Appeal Decision

Appeal Ref: APP/R5510/W/22/3309309

60 Long Lane, Ickenham, Middlesex UB10 8SZ

- The appeal is made under section 78 of the Town and Country Planning Act 1990 against a refusal to grant planning permission.
 - The appeal is made by Mr Veeru Parmar against the decision of the Council of the London Borough of Hillingdon.
 - The application Ref 70282/APP/2022/1143, dated 1 April 2022, was refused by notice dated 15 August 2022.
 - The development proposed is the demolition of the existing dwelling and erection of a two storey detached building with habitable roof space to provide 8 x 2-bed flats and 1 studio flat with associated amenity space and parking.
-

Plan 746.17.3A Tree Protection Plan

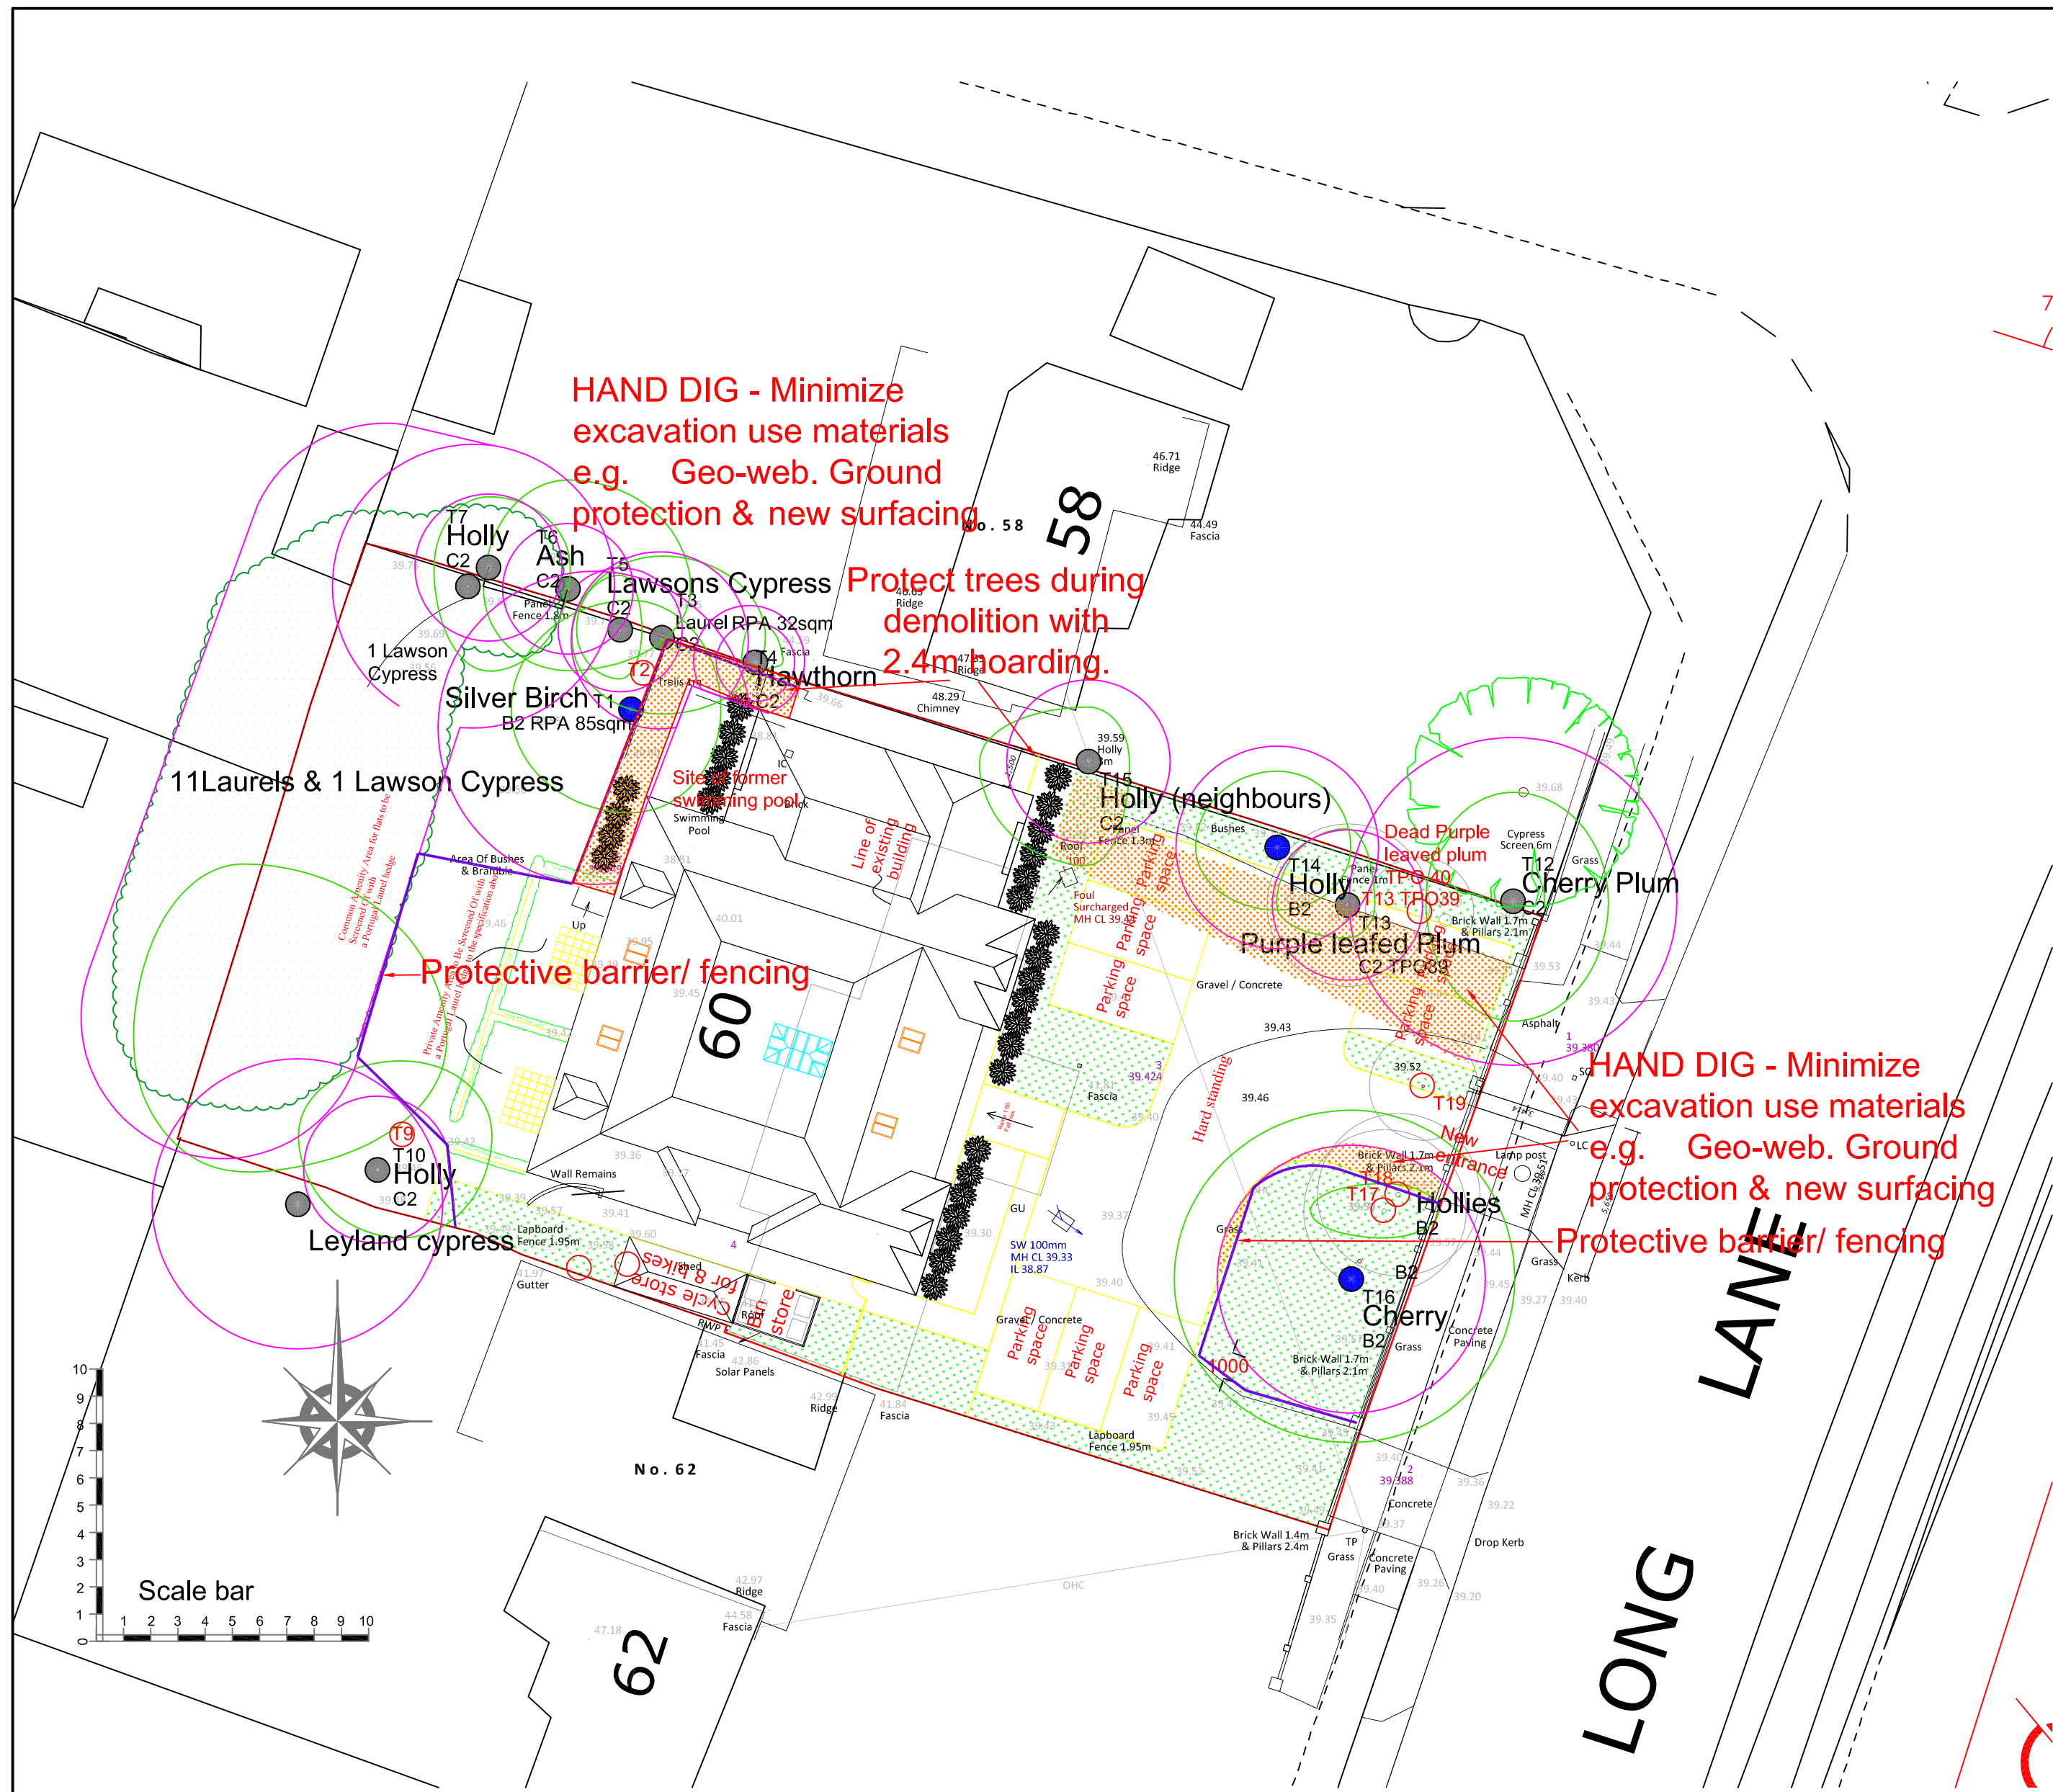
15. In addition, the amount and quality of tree cover contributes positively to the character and appearance of the CA and the appeal site is covered by a Tree Preservation Order. Tree information⁹ accompanies the application that includes a tree constraints plan showing the site has a notable number of category B and C quality trees. It is based on a survey of the trees undertaken in August 2017¹⁰. However, the report goes on to advise at paragraph 2.1.3 that if there is a change in site conditions it is important to re-survey the trees and re-evaluate them. In any event, the tree survey is only valid for a 3 year period from the date of the survey, meaning it is now out of date. Moreover, I am not assured that the development shown on the tree protection plan

matches the appeal proposal. Consequently, little weight can be attributed to the arboricultural information provided.

NORTH WEST ELEVATION

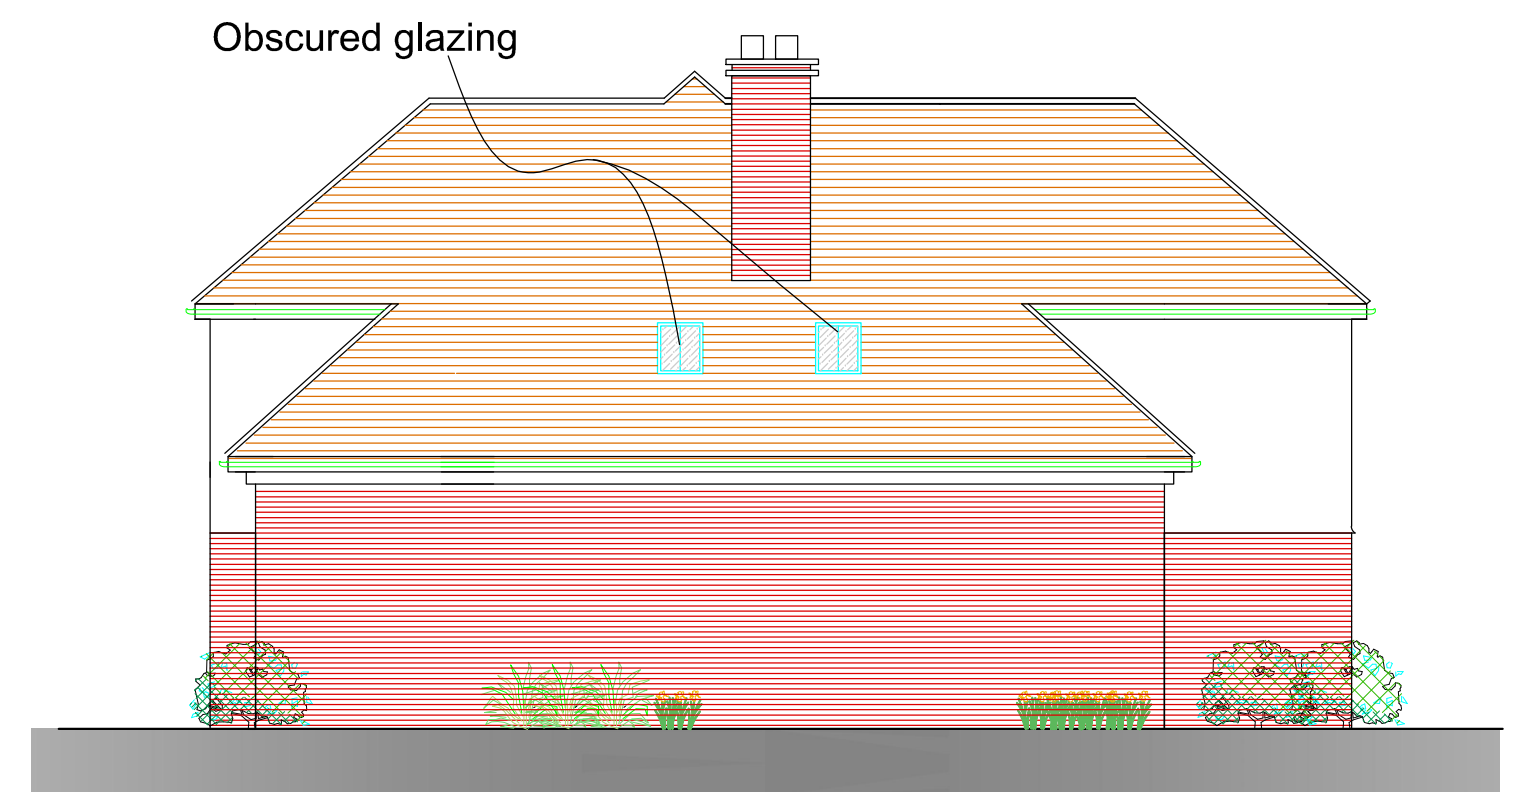
12. The proposal before me would alter the rear elevation in order to accommodate Flat 9 in the roof space. This would interrupt the hipped roof form by introducing a section of flat roofing and two rooflights. In turn this would lead to a central section of the elevation having a higher eaves line. In addition, it would include a central flat roofed dormer window, the proportions of which would give a horizontal emphasis. These measures would add complexity to the roof form and bulk to the rear upper part of the building and would appear discordant relative to the front elevation. Hence, by comparison to the approved schemes, the appeal proposal would represent a retrograde step in design quality and would more overtly convey an impression of flattened development.

13. Albeit that the crown roof in the appeal scheme is smaller than that proposed in the 2021 appeal scheme, my findings are generally consistent with the approach of the Inspector who considered that the use of a crown roof would be out of keeping.

ROOF PLAN

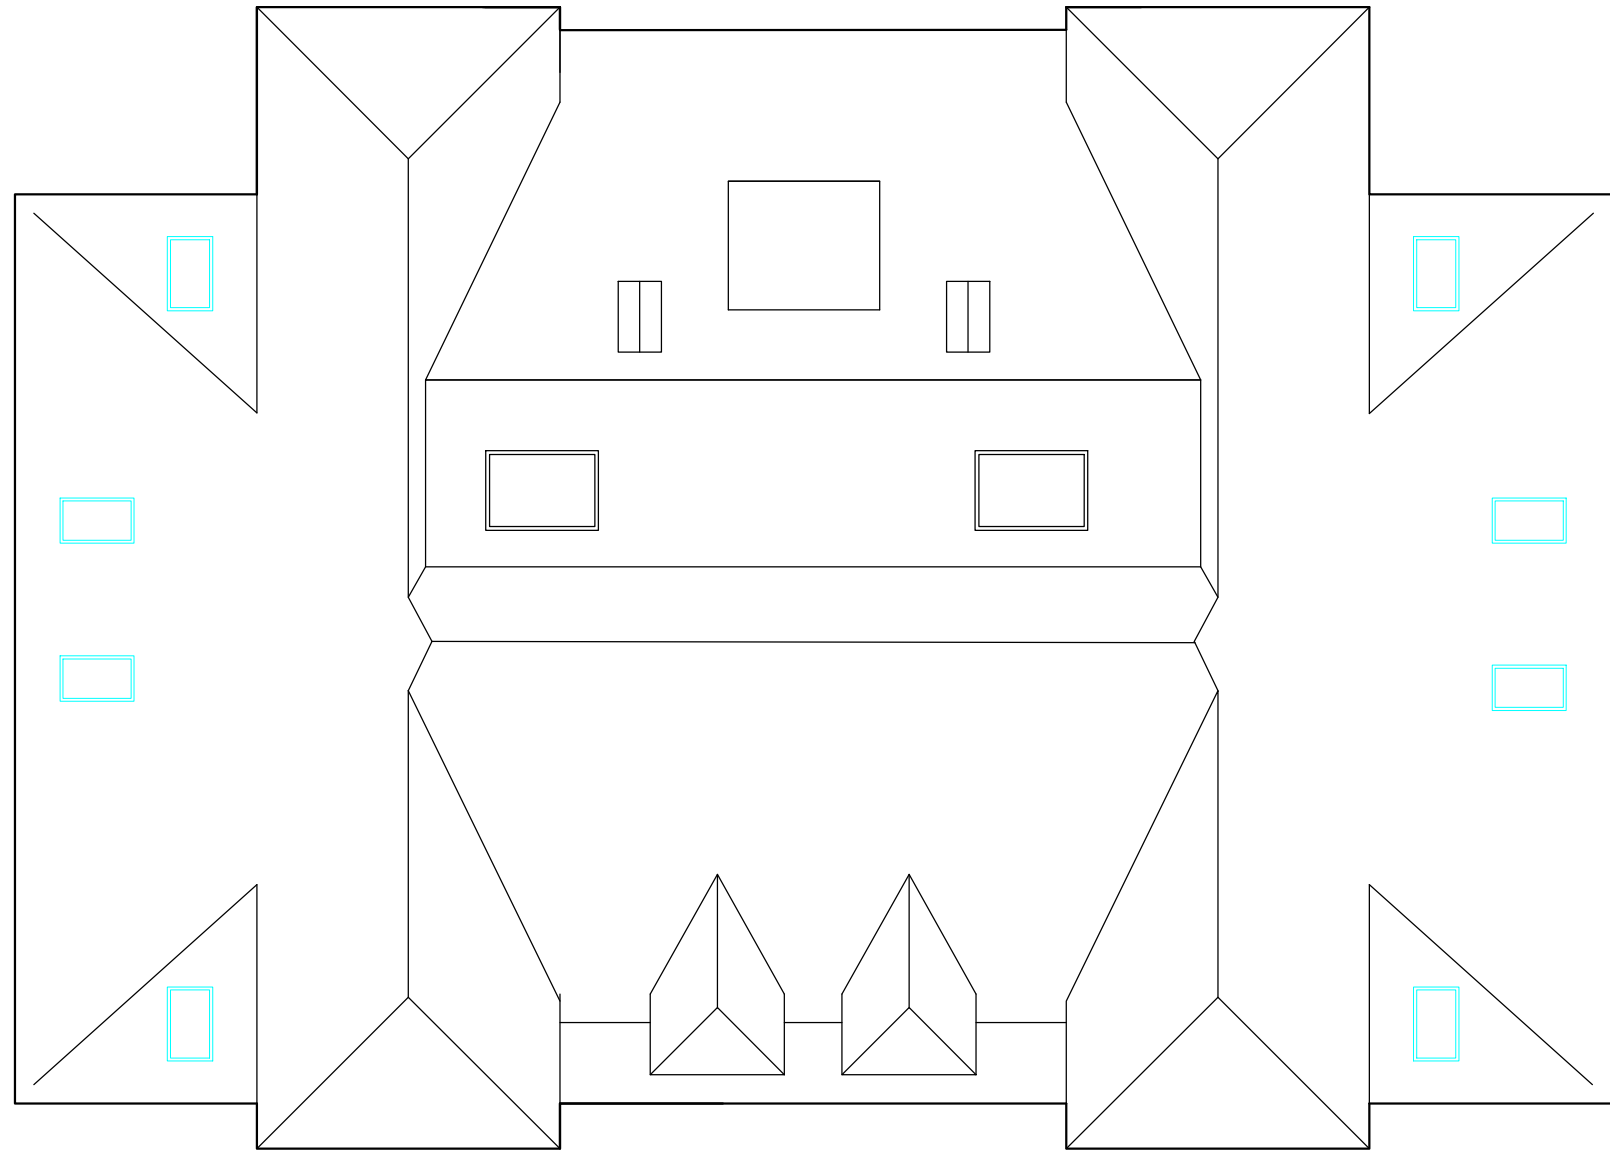
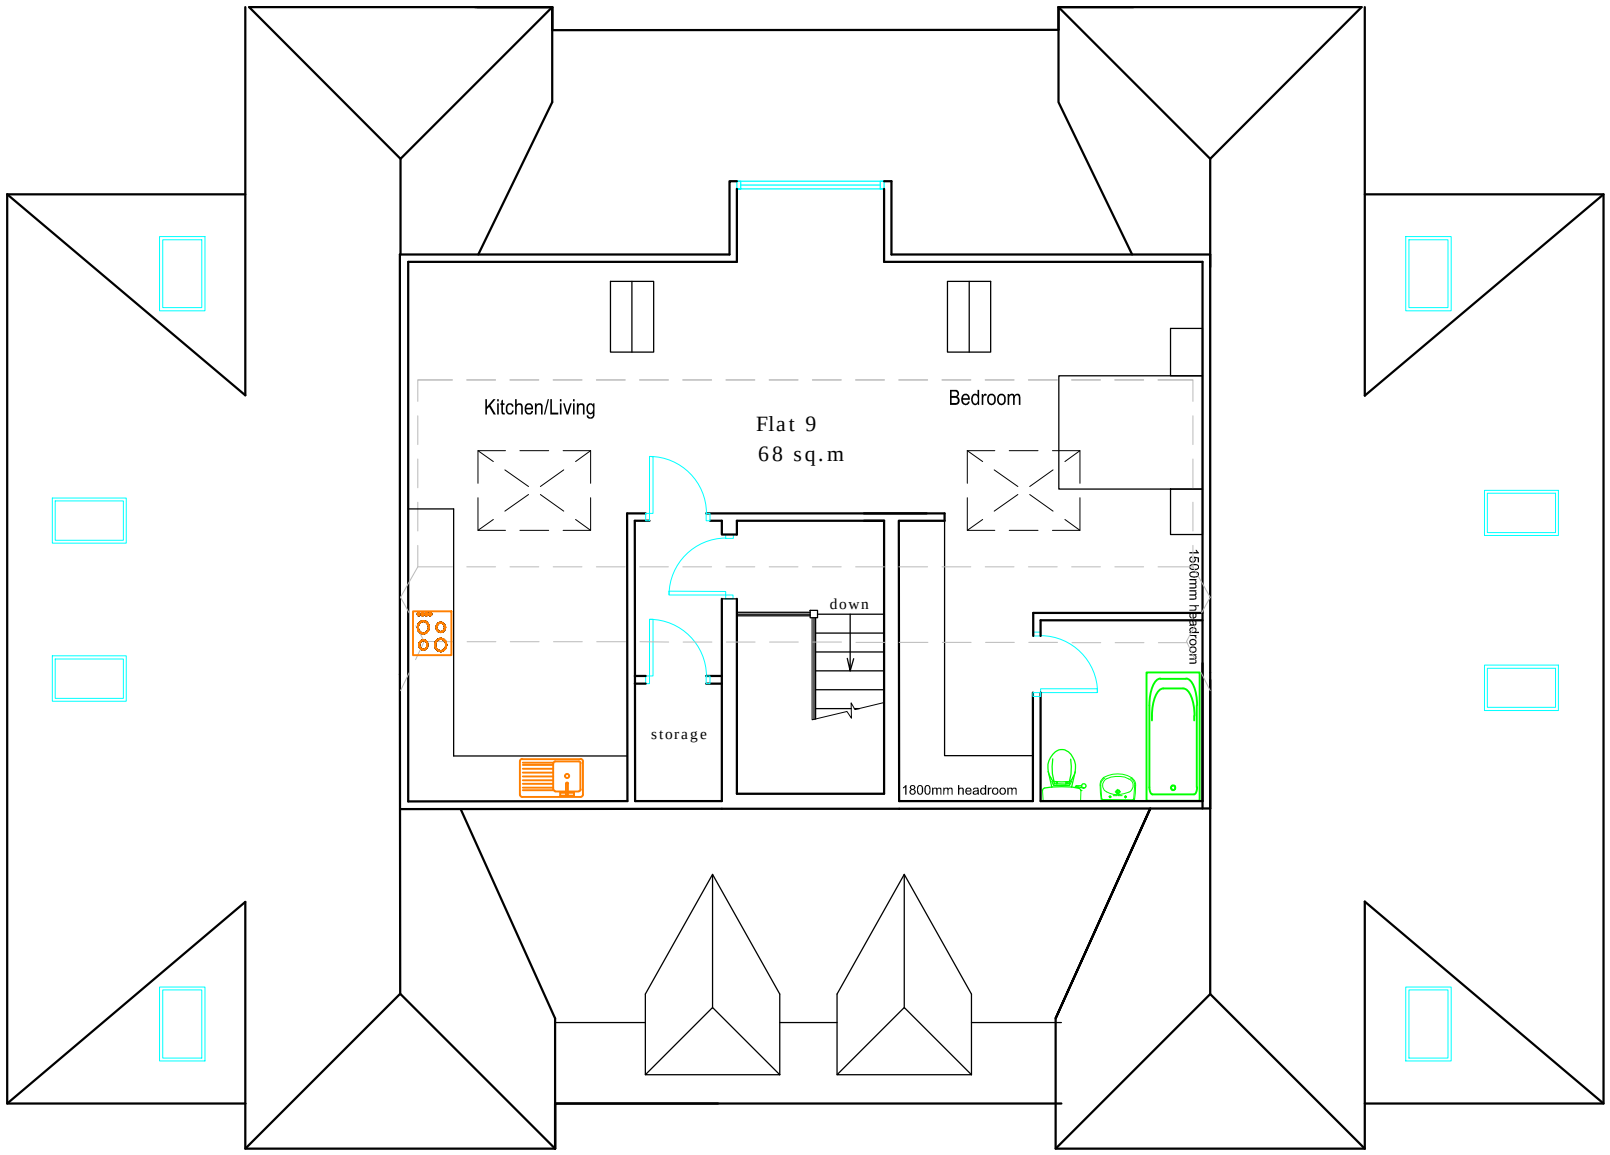
25. The proposed roof plan indicates that Flat 9 would have 68m² GIA, but it is not otherwise clearly articulated whether this unit is intended as a one, or two person dwelling, nor what the headroom within the roof space available across the unit would be. Hence, doubt remains as to whether this unit would fully adhere to the mandatory space standards in the development plan. Consequently, I am not assured this unit would provide suitable living conditions for future occupants.

26. The Council also raise concerns regarding the outlook available for future occupants of Flat 9. However, the flat would be served by two overhead rooflights, two further rooflights within the roof slope and a centrally positioned rear facing dormer window. In combination these would provide a reasonable view from the bedroom and main living area of the flat.
